NC-MCD-102 W Cornelius Harnett Blvd (Town of Lillington NC)

Civil / Site Plan Coordination Review Items – 12/12/2024

Remaining Building Review Recommendations – 12/12/2024

**C-3**  
SITE LAYOUT PLAN

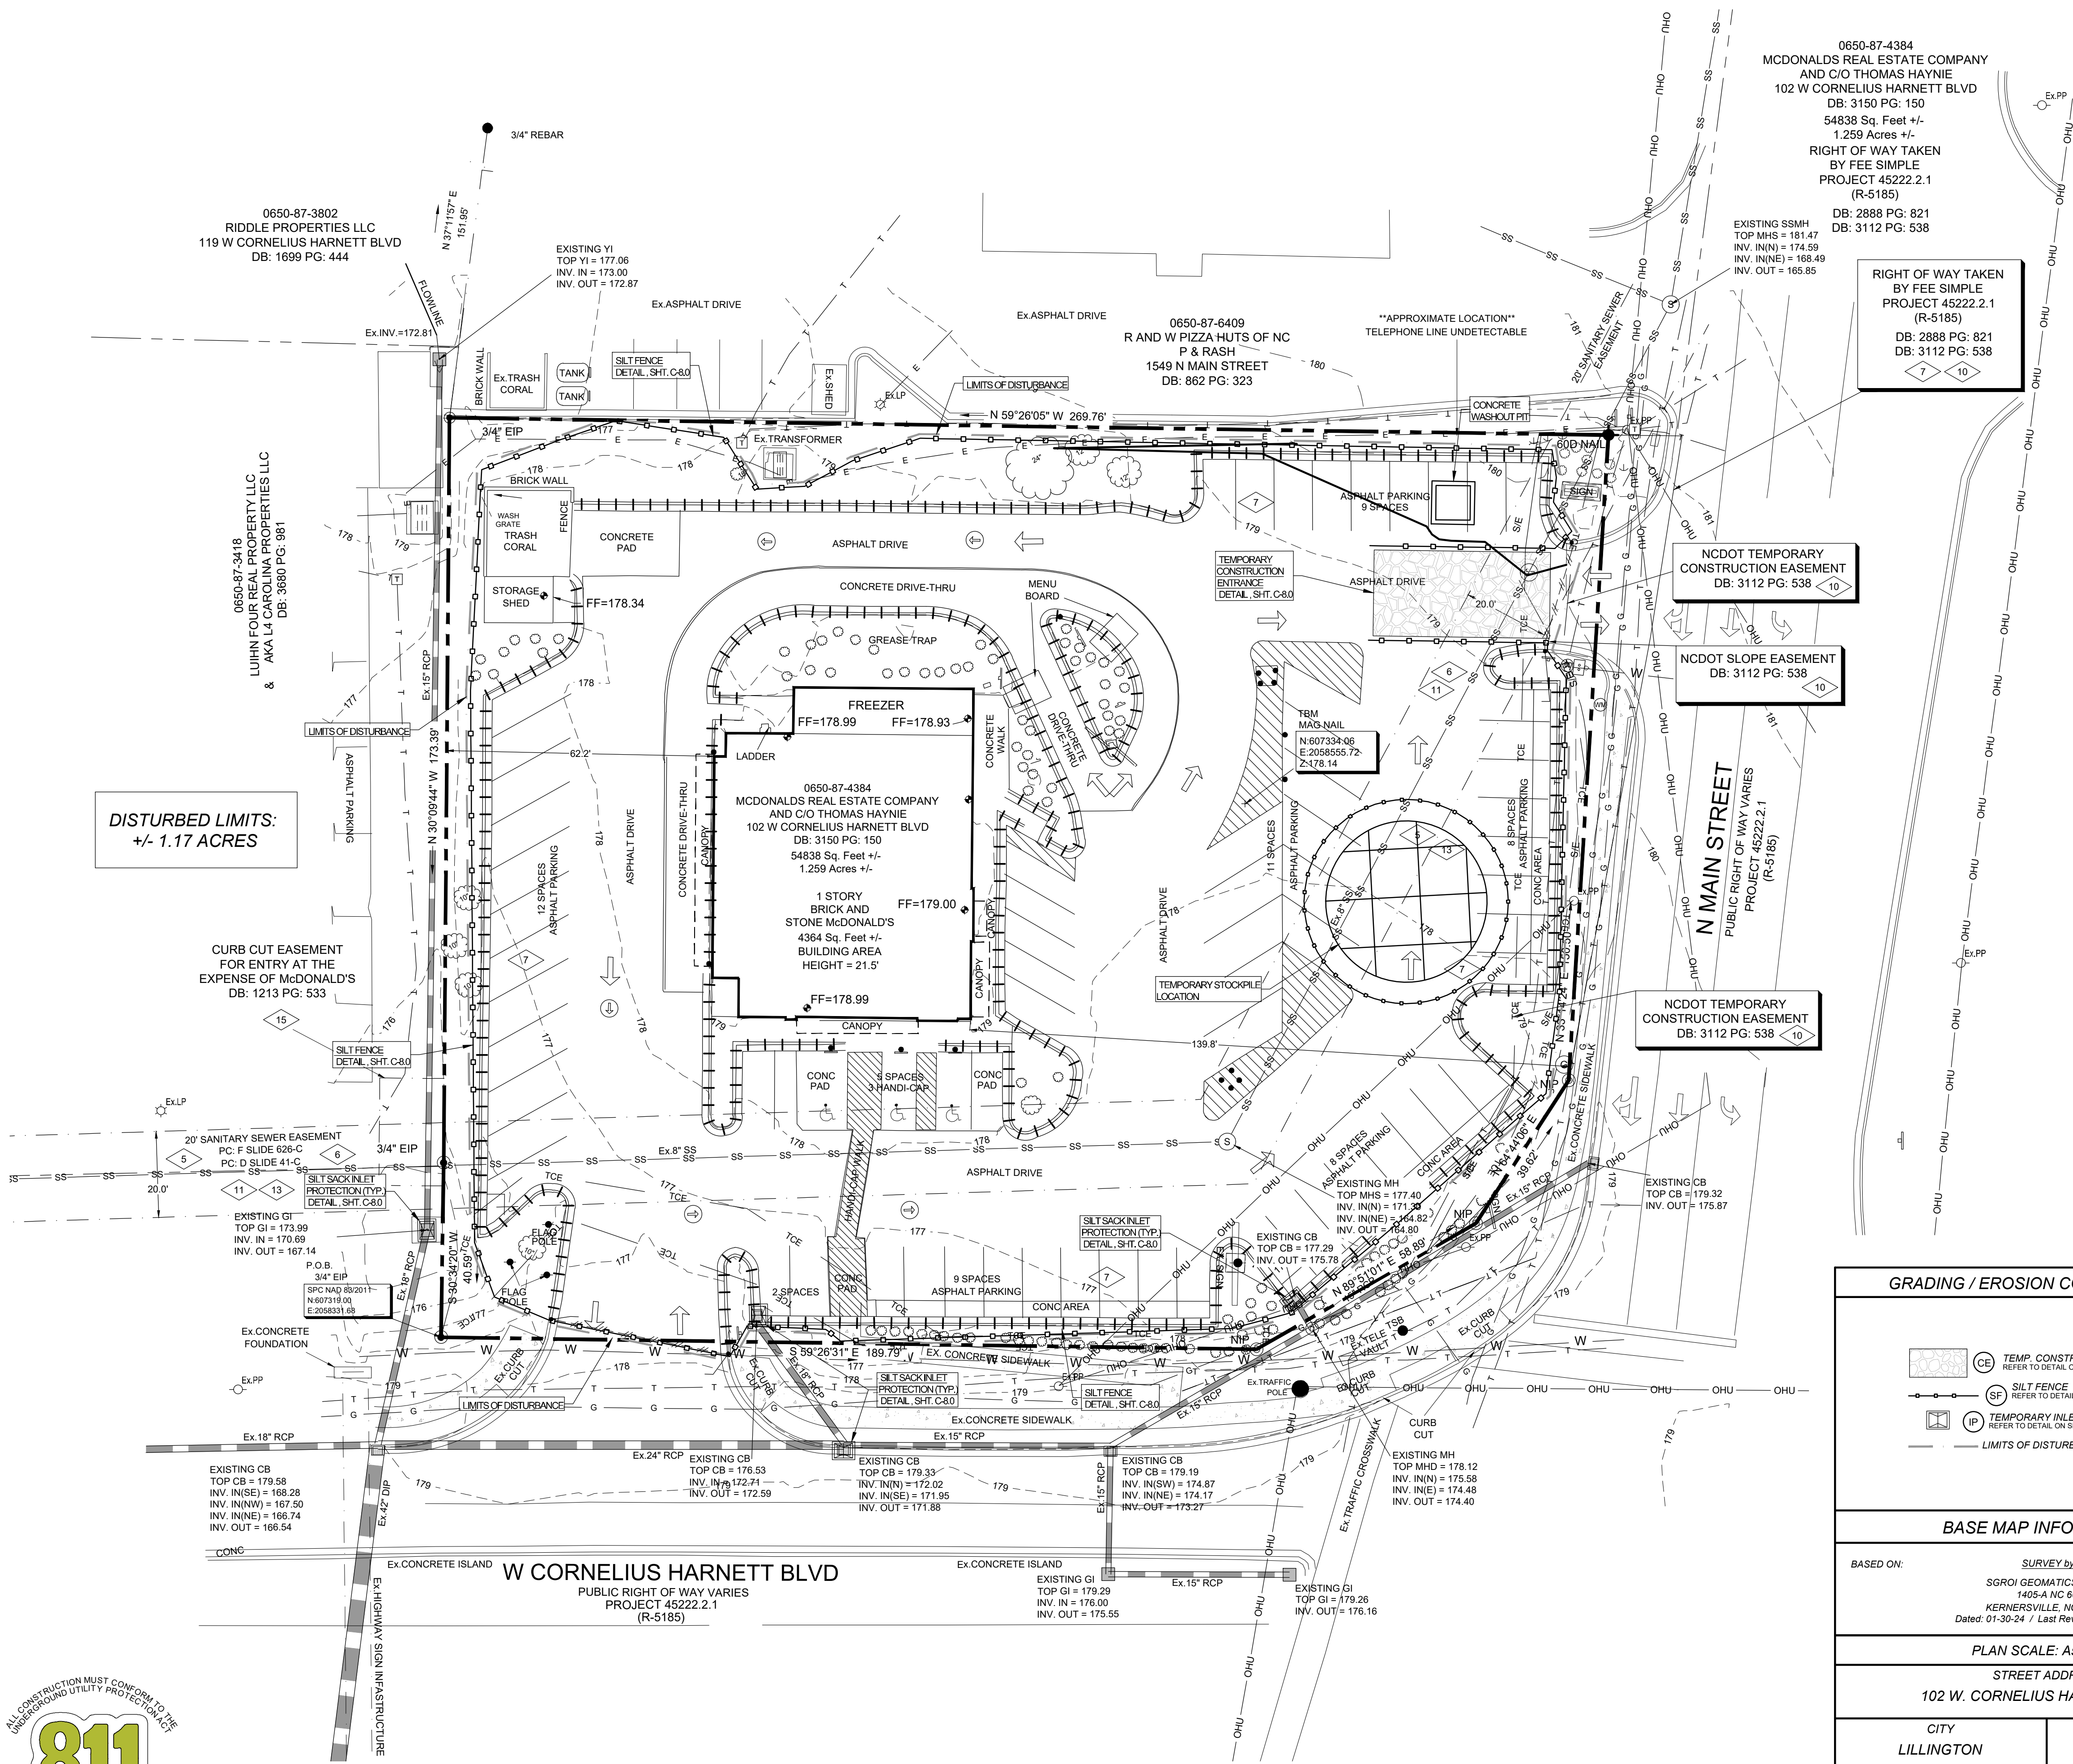
- 1) Site Plan Sheet C-3 refers to Sheet TC-1 (By Others). Sheet TC-1 is not included in either plan set.
- 2) Architectural Plan A6.1 Detail 1, Bollard Detail, does not match Site Plan Sheet C-7 Bollard Detail.

**C-6**  
**SITE UTILITY PLAN**

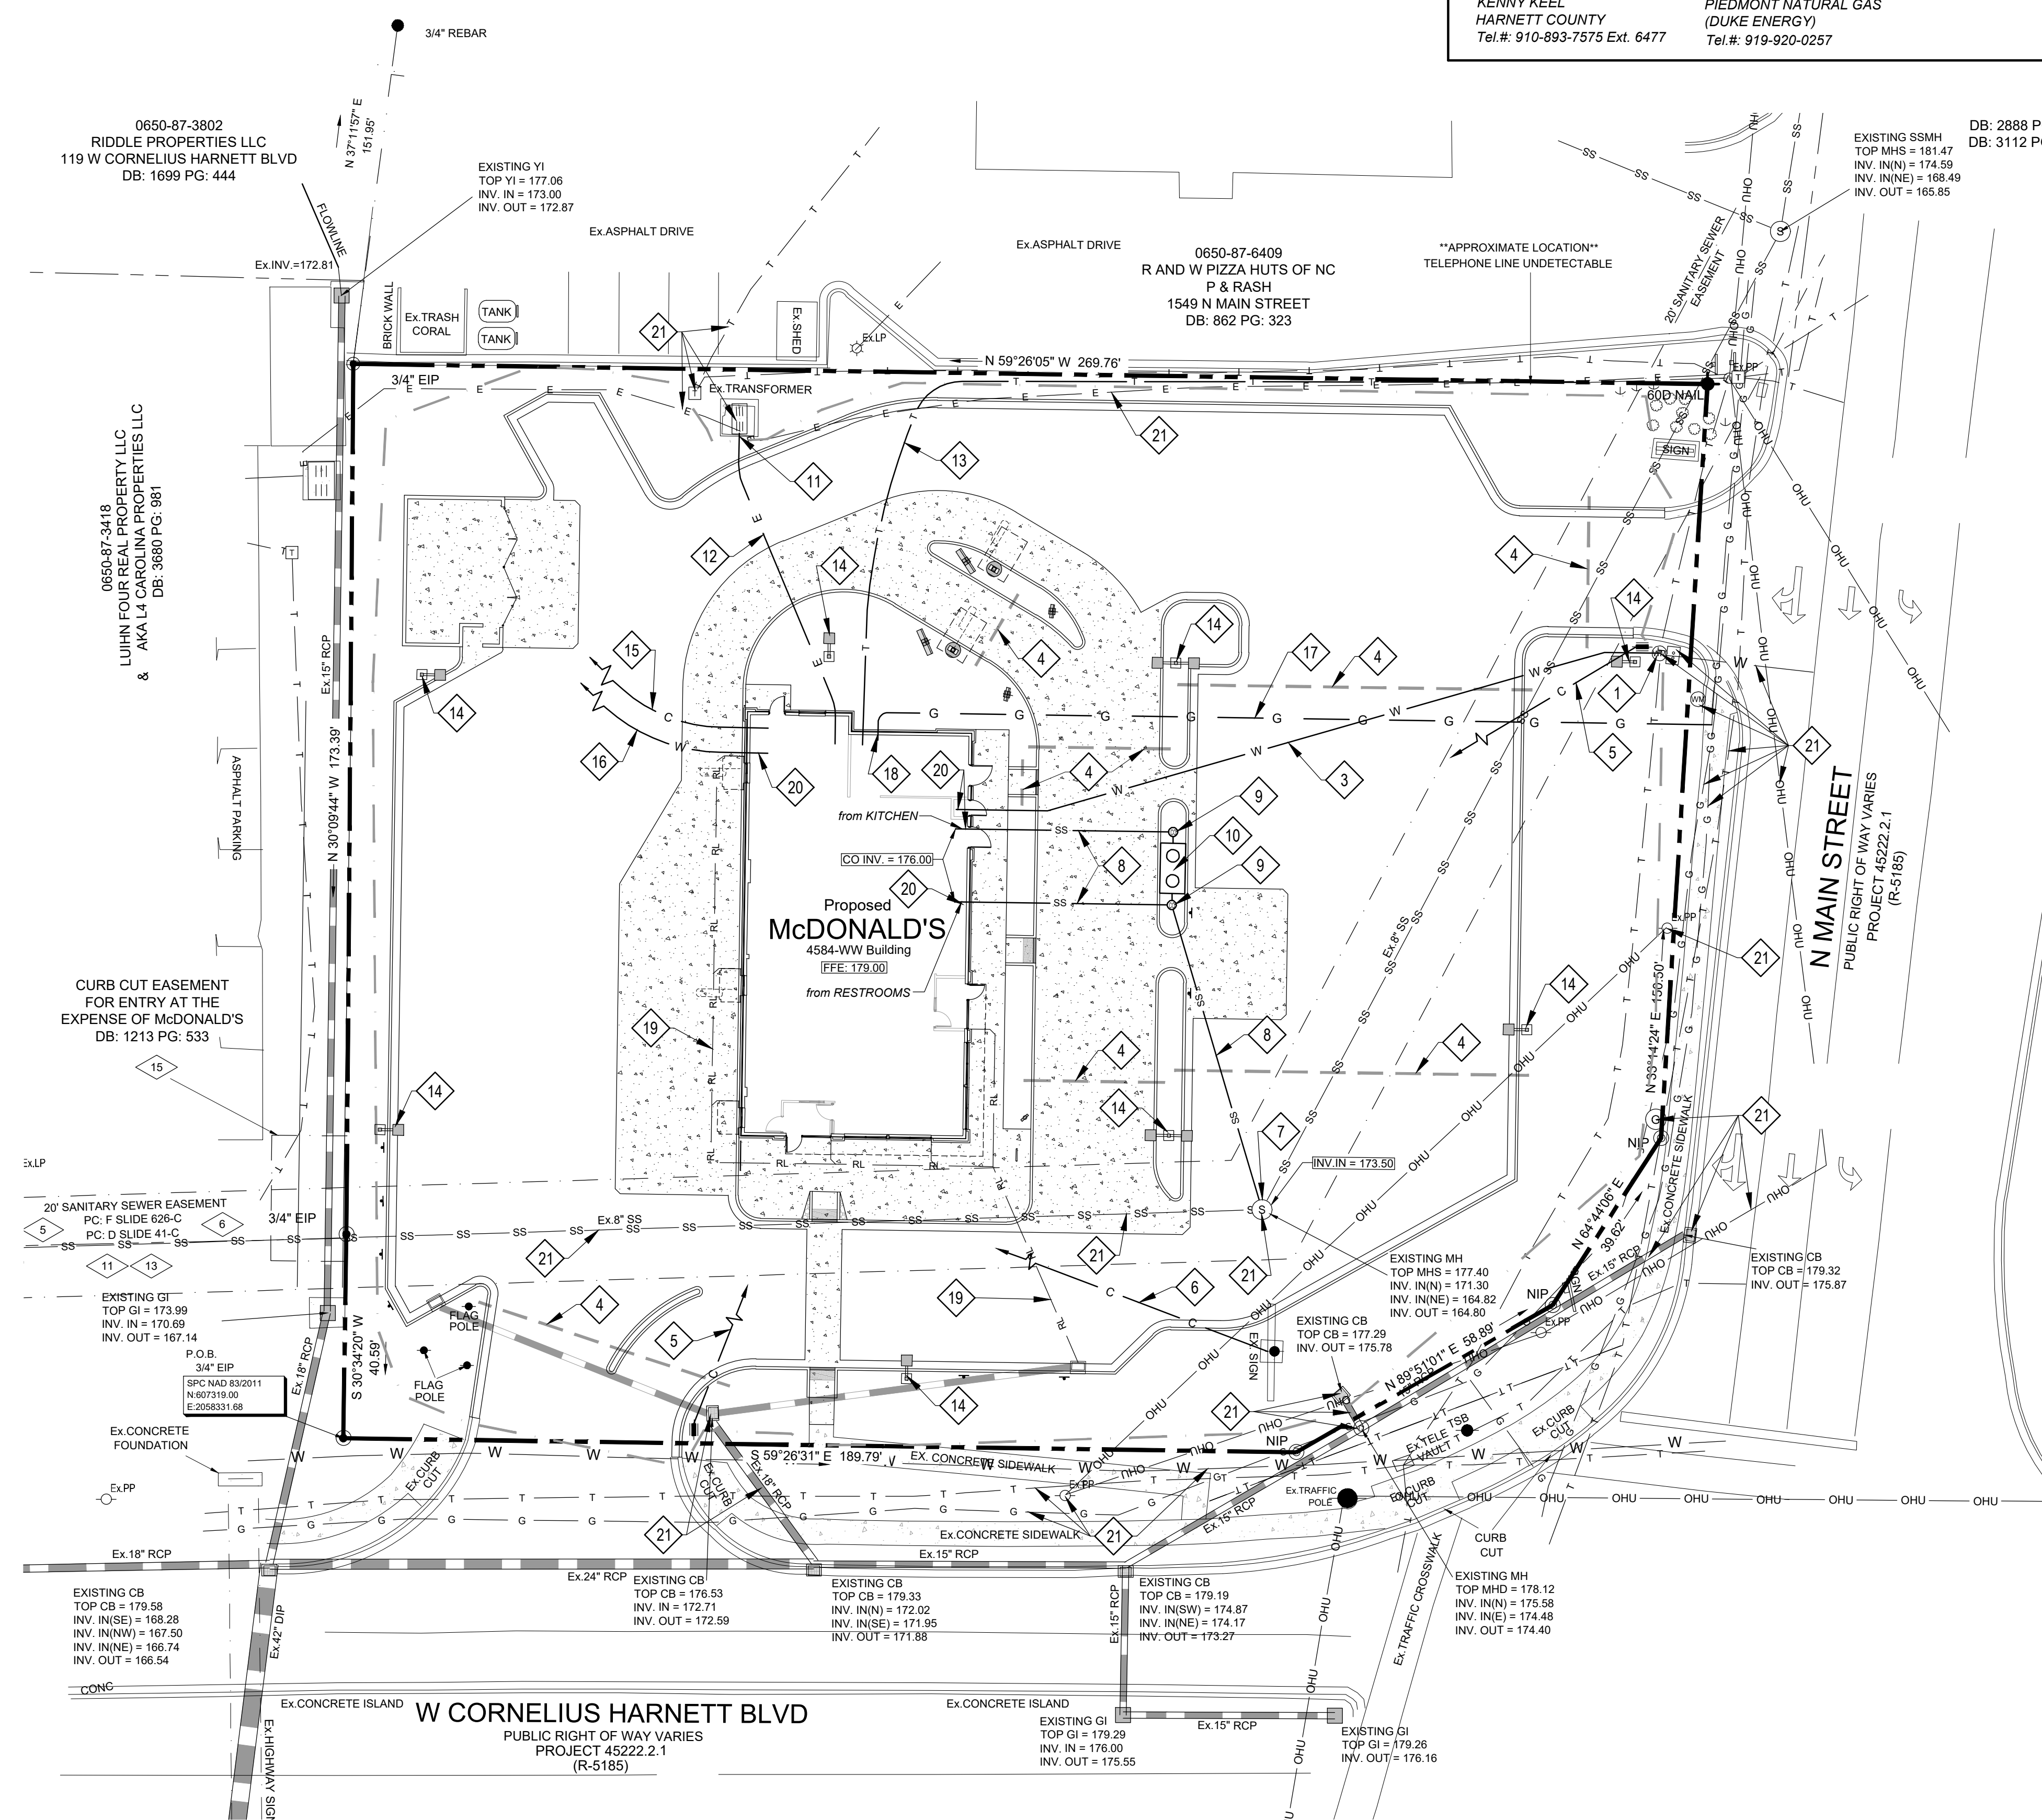
- 3) The water and sanitary sewer connections shown on Plumbing Plan Sheets P1.0 and P1.3 do not match the water and sanitary sewer connections shown on Site Plan Sheet C6.

- 4) Plumbing Plan Sheet P1.0 Keynote P2 refers to cold water to yard hydrant in trash corral, with continuation on site plan. Site Plan Sheet C-6 Keynote 16 refers to hot water to hose bib at dumpster location with details on plumbing plans. This is a conflict between plan sets.

- 5) Plumbing Plan Sheet P1.0 Keynote P14 is not physically possible based on layout of sanitary sewer on Site Plan Sheet C6.
- 6) Plumbing Plan Sheet P3.0 shows a 1600-gallon grease interceptor. Site Plan Sheet C-6 Keynote 10 refers to a minimum 1500-gallon grease interceptor. While this is not a conflict, it may create confusion for a reviewer.

- 7) Plumbing Plan Sheet P3.0 includes details for a two-inch water meter and backflow preventer inside of the building. Site Plan Sheet C-6 notes that the existing 1-1/2 inch water meter at the property line will be reused, with a new backflow preventor to be installed at the property line. This is a conflict between the plan sets.
